27 October 2022

Re: planning application No 3/2022/0924 resubmission of 3/2021/0770

PROPOSED
ELEVATIONS

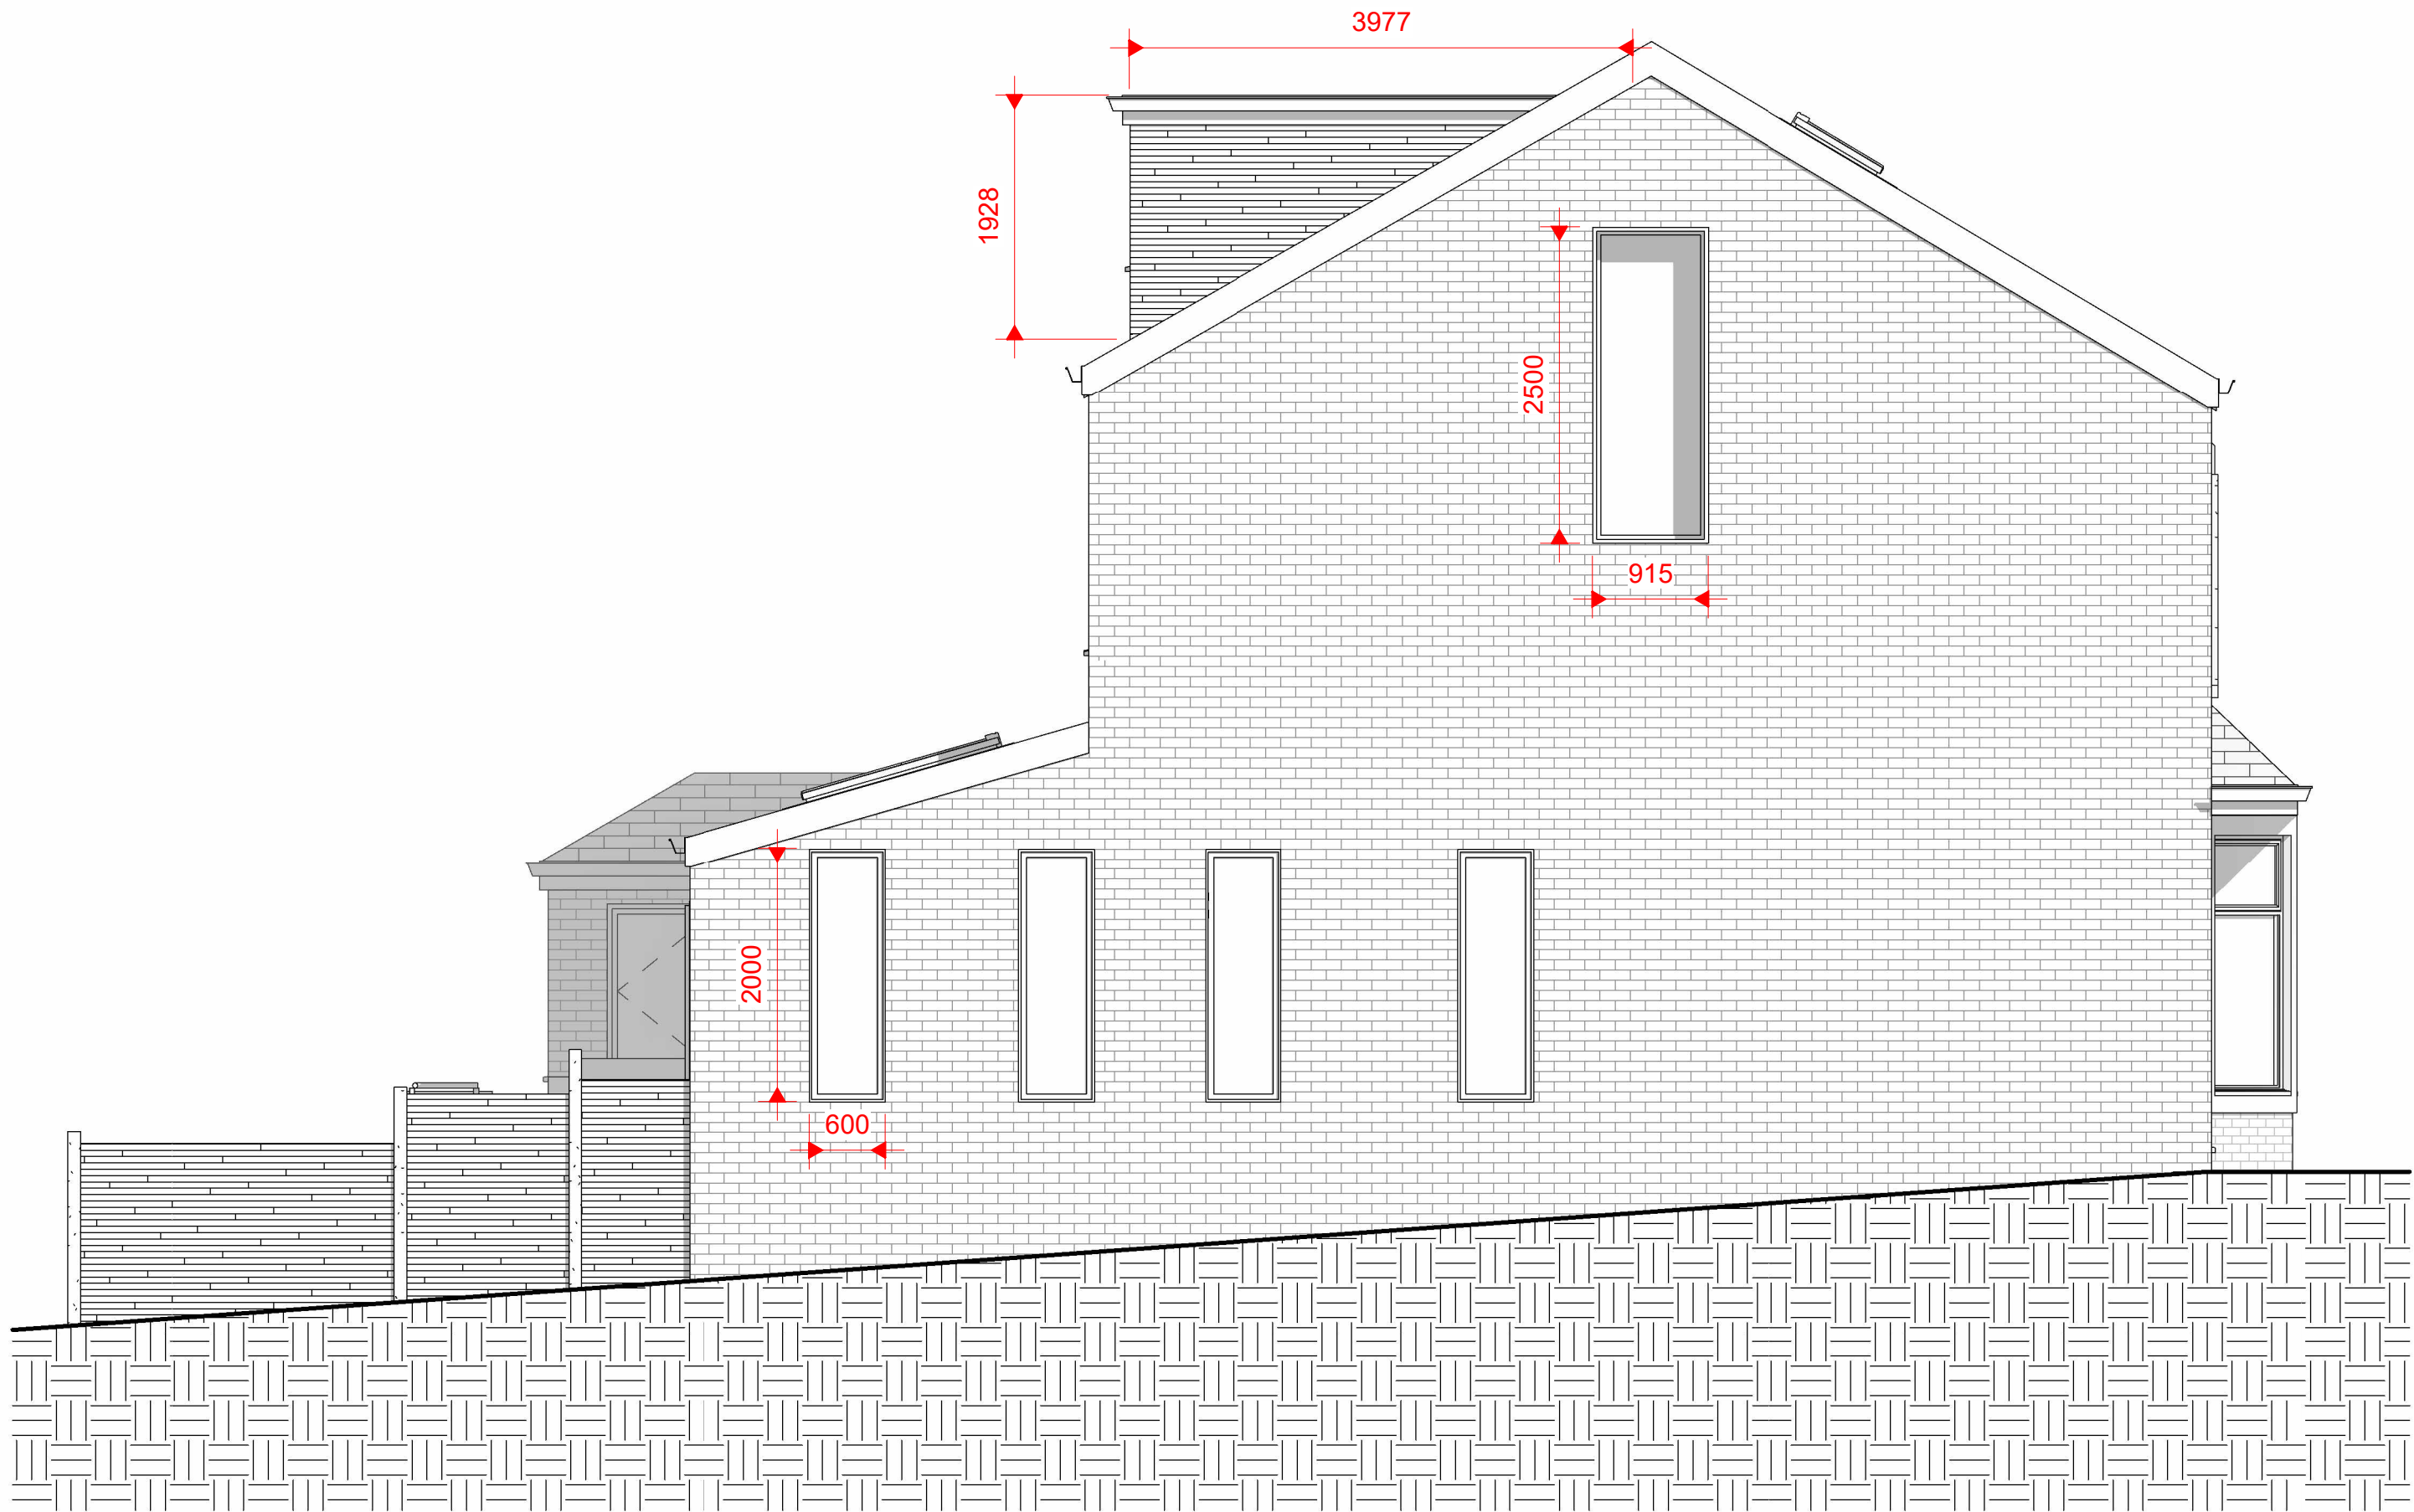
[redacted] There is no indication on the plans as to what facade material is going to be used.

The proposed extension will be much higher than the existing fence due to it being hard up to the boundary unlike the existing extension which is set back from it. I consider the height of the proposed extension to be **overbearing due** [REDACTED]

1. [REDACTED]
2. [REDACTED]
3. Proximity and height of their planned new living room [REDACTED]
[REDACTED] (roof height is much higher than anticipated only being reduced by 4 brick courses according to the plan. Query roof height of building once current kitchen demolished and new 'lowered' building is completed.
4. [REDACTED]
5. I am extremely concerned that by extending their original living room plan by another 0.8 metres in length, and the height of new build being much greater than anticipated that the proposed development will [REDACTED]

1 0 PROPOSED GROUND FLOOR
1 : 50

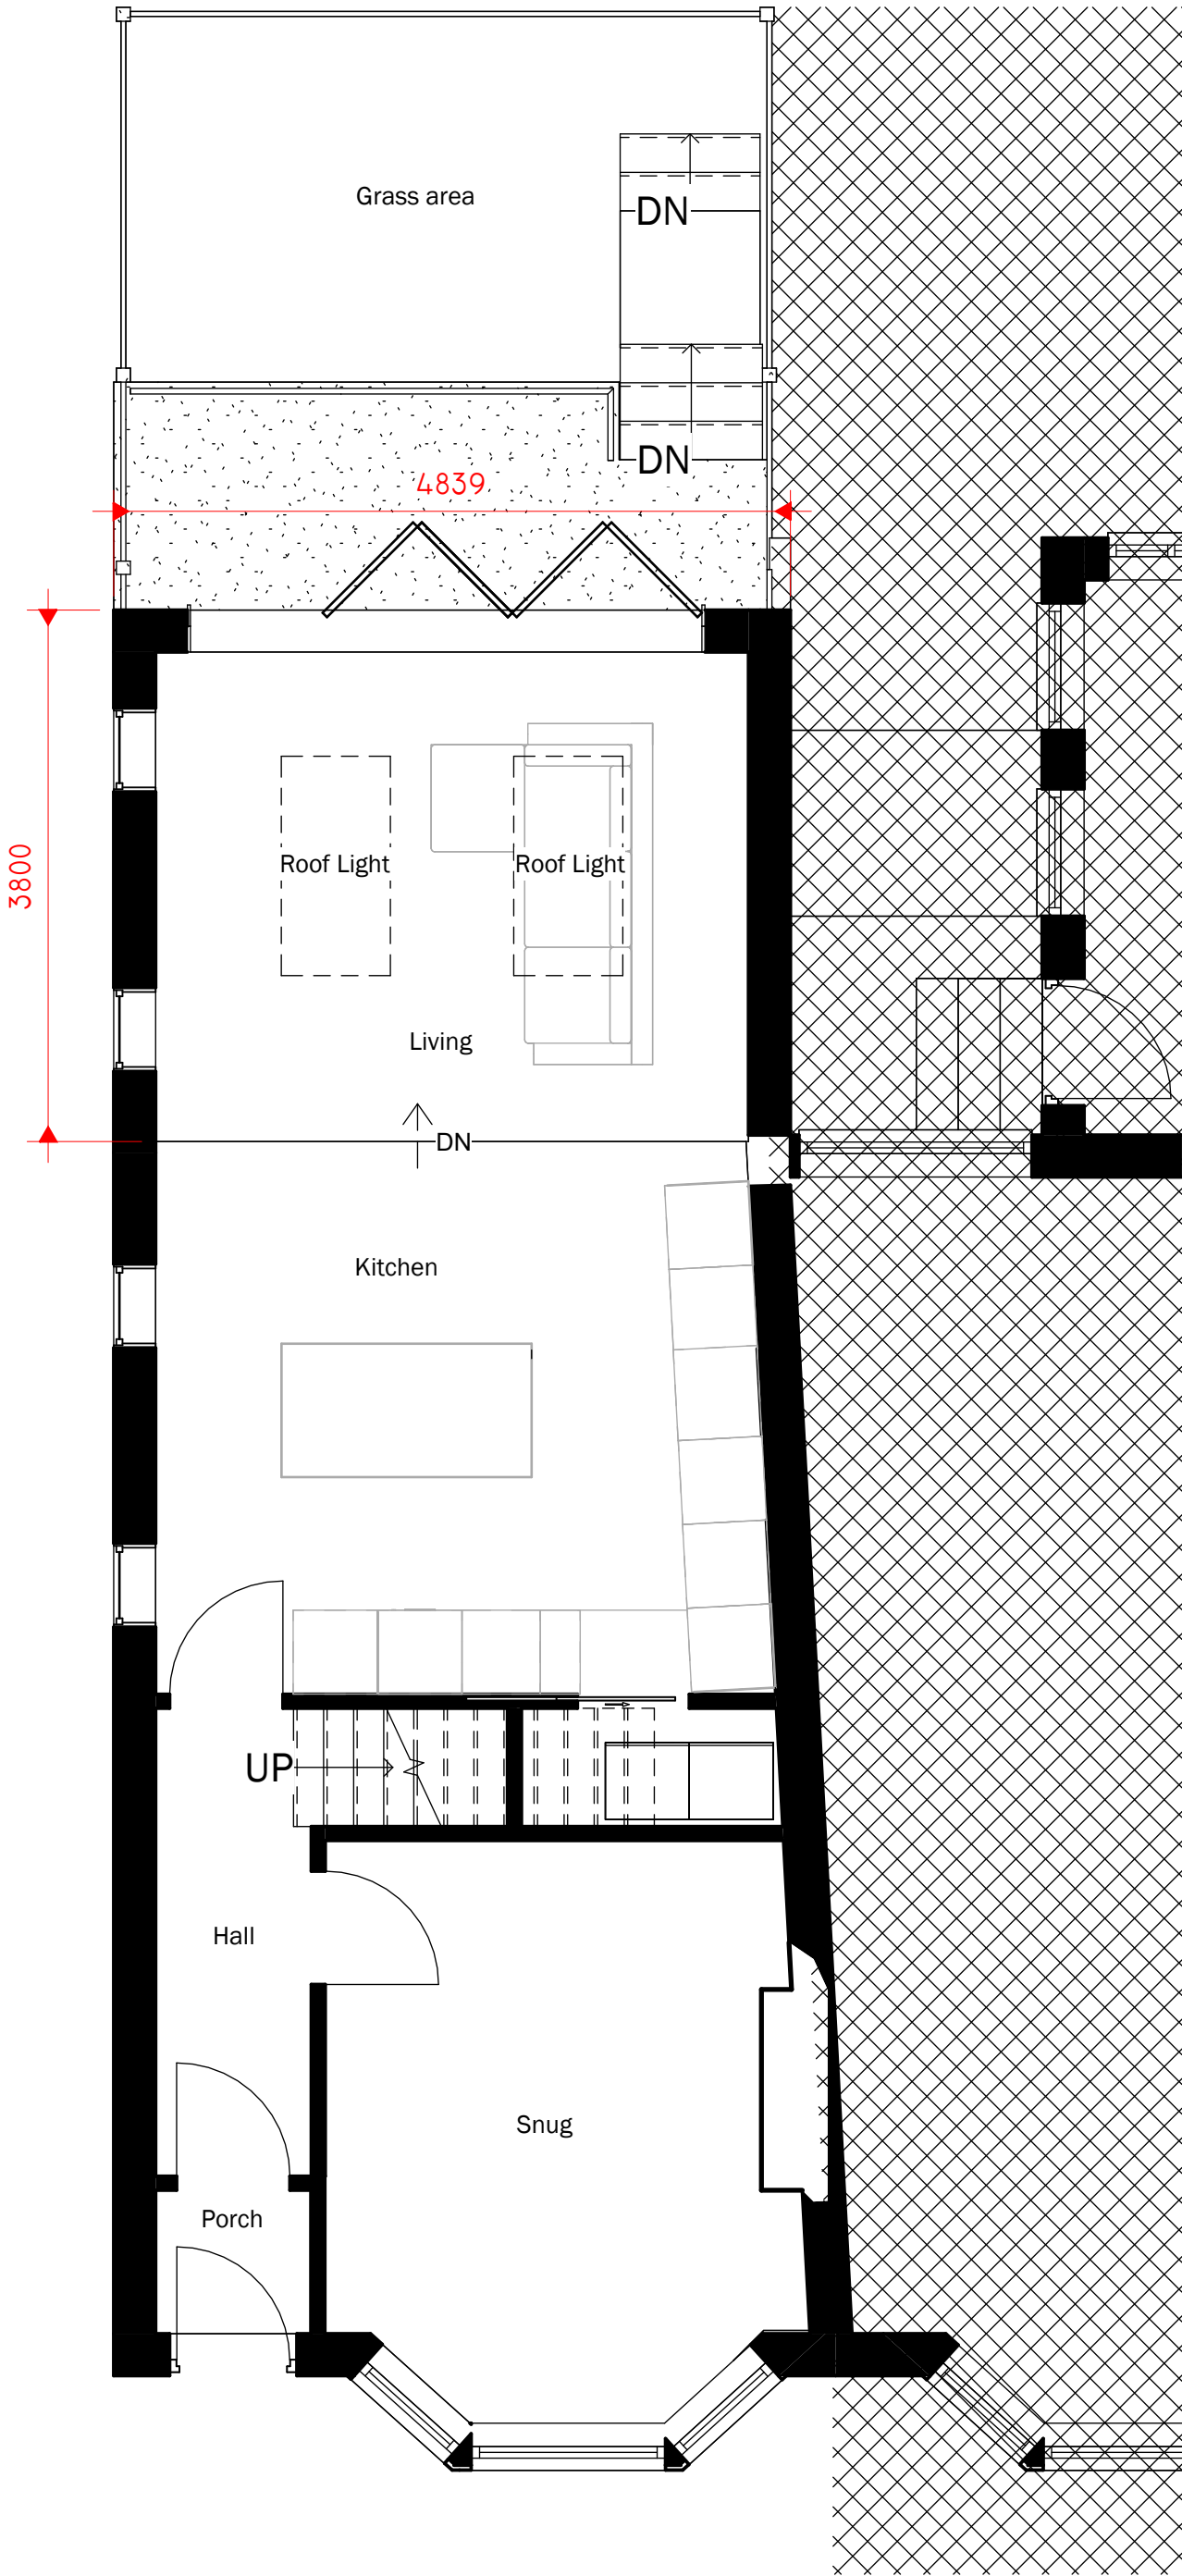
I strongly object to the extra 0.80 length projection of their planned living area (other neighbouring properties [redacted] have not extended in length). [redacted] has expressly promised that the new building would be much lower than their current kitchen and they would not be building beyond their current kitchen build line.

The widening of the proposed extension will bring its external wall hard up against the rear boundary between the two properties, [redacted] and the rear [redacted] It will also bring the external wall of the proposed wider extension within approximately 1620mm (5' 3") of the two windows to the [redacted]

[redacted] their plans compensate for their loss of light to their dining room window which they are proposing to build over by installing two roof windows, three new side windows and four fully glazed external doors in their proposed extension. I am not in a position to compensate for the [redacted]

[REDACTED] I also consider that by raising the level of the proposed rear balcony area above the original level of the floor of the existing garage (or existing garden level) that is proposed to be demolished, [REDACTED]
